KITTITAS COUNTY

MEMORANDUM

TO: All Staff
FROM: Justin Turnbull, County Surveyor 
DATE: August 25, 2021
SUBJECT: County Survey Review of BL-21-00010 No. 9 Ranch 2

PART OF THE SOUTHEAST QUARTER OF SECTION 29,
TOWNSHIP 19 NORTH, RANGE 18 EAST, W.M.

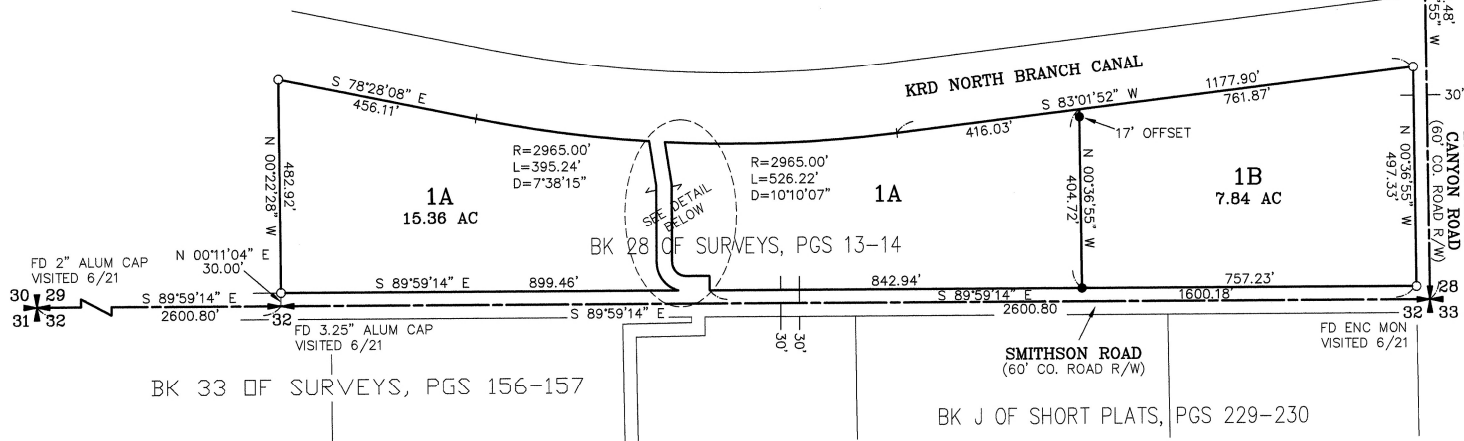
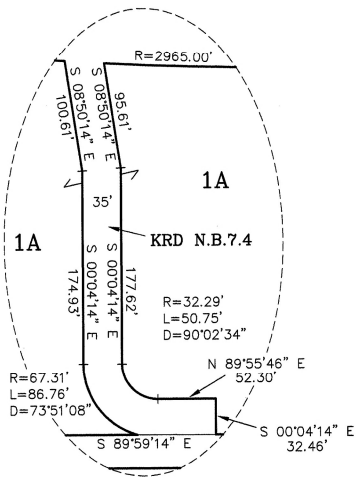
Sheet 1

1. Revise Original Legal Descriptions to reflect 2004 Segregation.
2. Note what was found (or Calc) for the East Quarter Corner of Section.
3. Label Lower Green Canyon Road (60' Co. Road R/W).
4. Please show offset distances from section line to parcel lines.
5. The distance conversion located under the graphic scale should reference note 8.
6. Revised parcel descriptions should reference 202109 _____
